**KIRKLEES METROPOLITAN COUNCIL
DEVELOPMENT & MASTER PLANNING SERVICE**

**DELEGATED DECISION FOR PRIOR APPROVAL FOR CHANGE OF USE
FROM COMMERCIAL, BUSINESS AND SERVICE USES TO
DWELLINGHOUSES**

Reference no. 2023/CL/92836/W

**Site Address 1st & 2nd floors, 9-13, Market
Walk, Huddersfield, HD1 2QA**

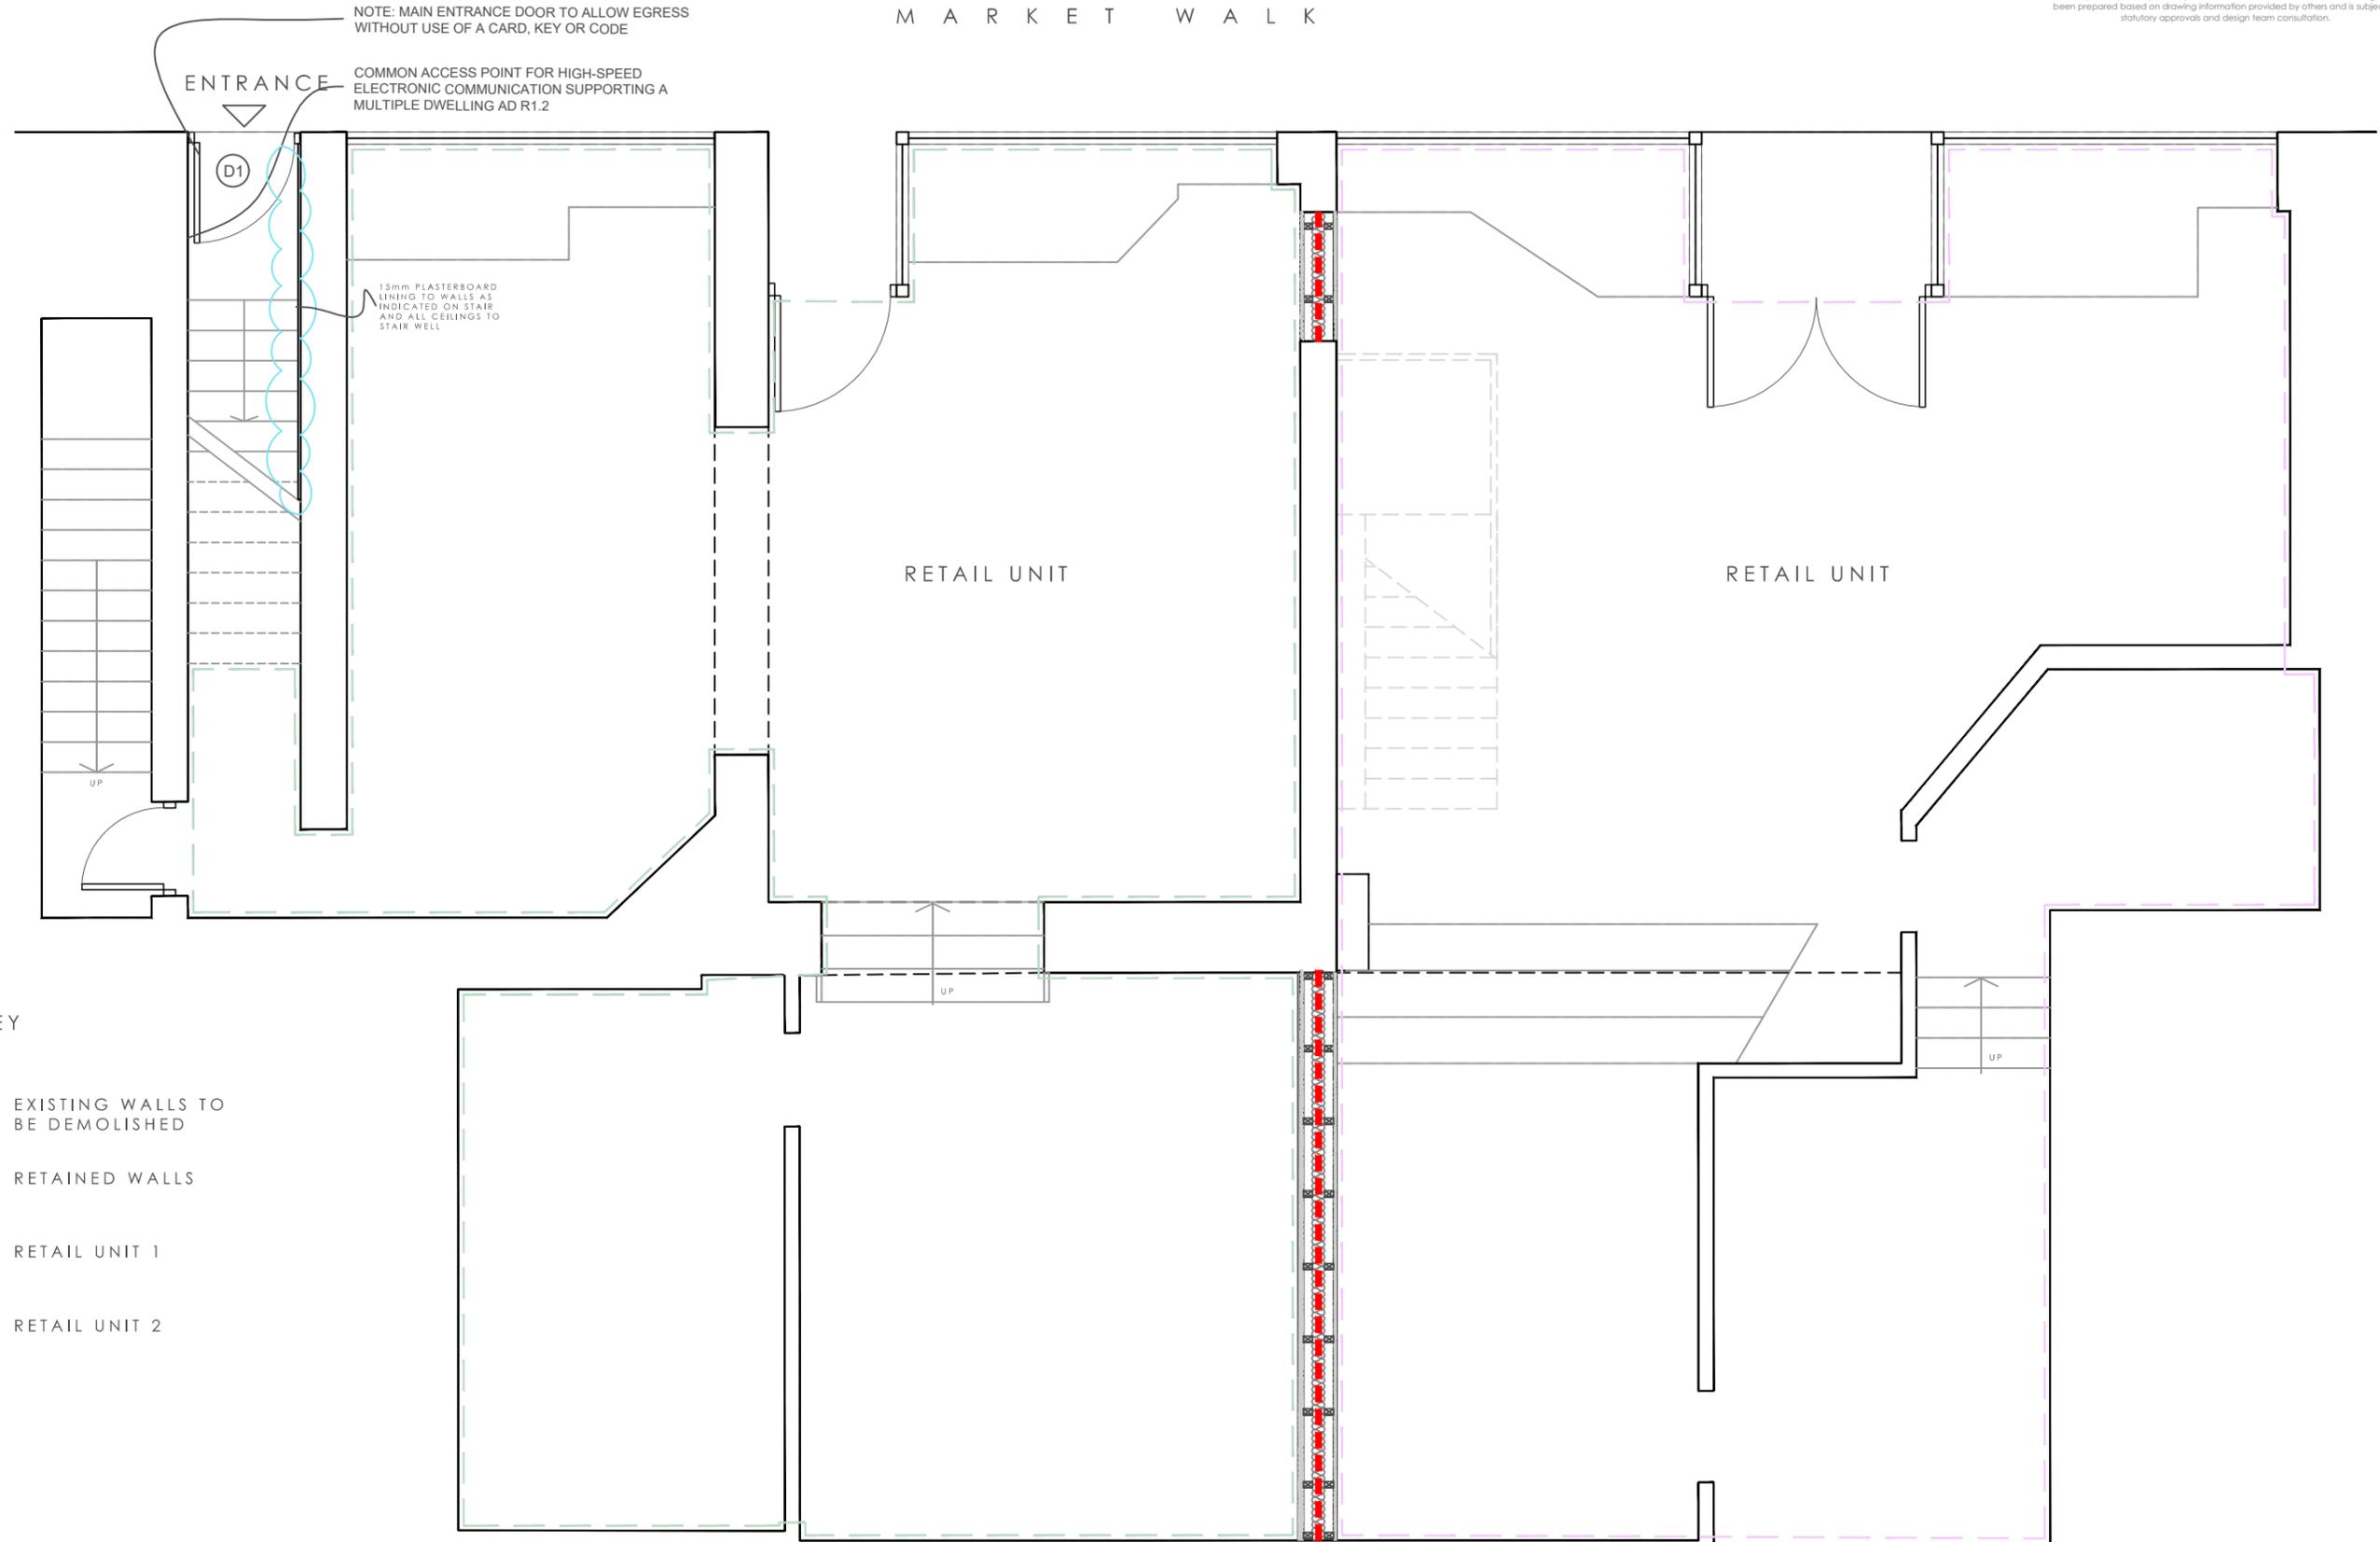
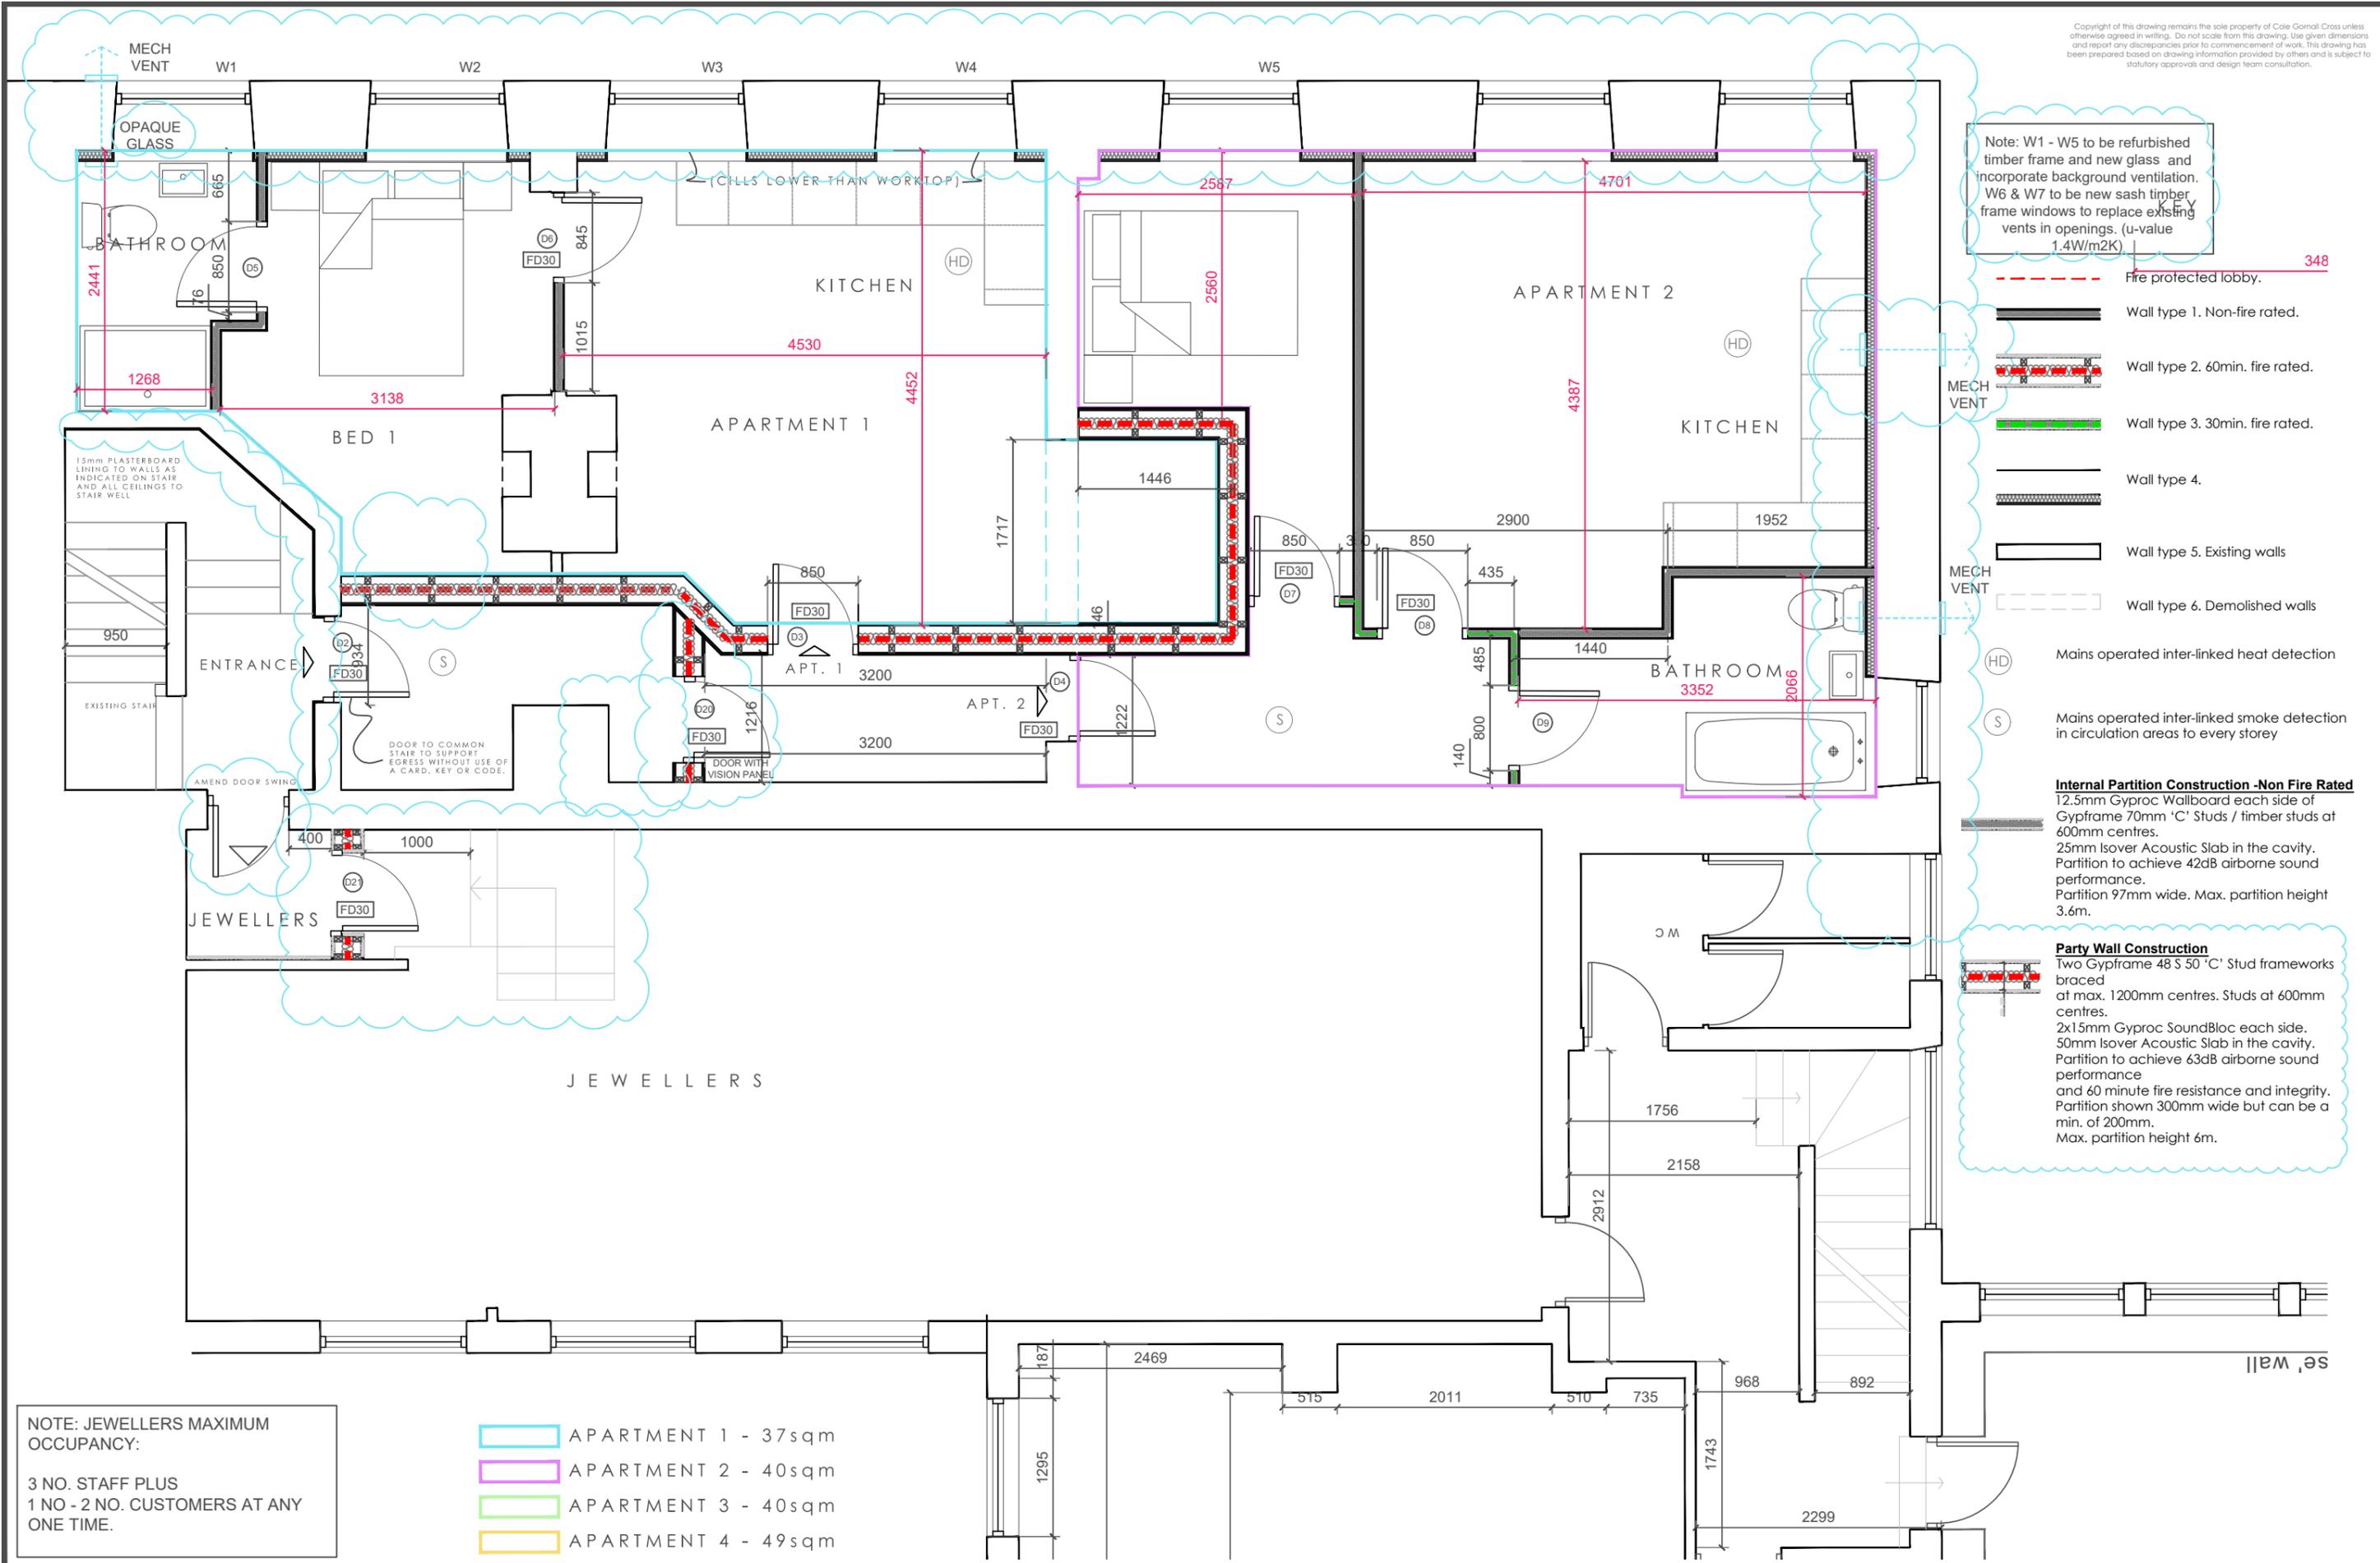
Apartment 1 is proposed to be a one bedroom first floor flat. The Technical Housing Standards document states that a one-bedroom flat for one person (minimum assessed) one storey should be at least 37 or 39 square metres dependant on whether the bathroom has a shower. In this instance, the internal accommodation is proposed to approximately 30.7 square metres which would not accord with the recommended space standards. However, the bedroom is shown to sleep two persons which requires 50 square metres of space, thus contrary to space standards.

Apartment 2 is proposed to be a one bedroom first floor flat. The Technical Housing Standards document states that a one-bedroom flat for one person (minimum assessed) one storey should be at least 37 or 39 square metres dependant on whether the bathroom has a shower. In this instance, the internal accommodation is proposed to approximately 34.6 square metres which would not accord with the recommended space standards. However, the bedroom is shown to sleep two persons which requires 50 square metres of space, thus contrary to space standards.

The application has not been submitted with sufficient information to allow the Local Authority to assess the noise impacts. It is also considered that the internal gross floor space of Apartments 1, 2, 3 & 4 would not meet the space standards for the two double bed spaces proposed, therefore the application is to be refused.
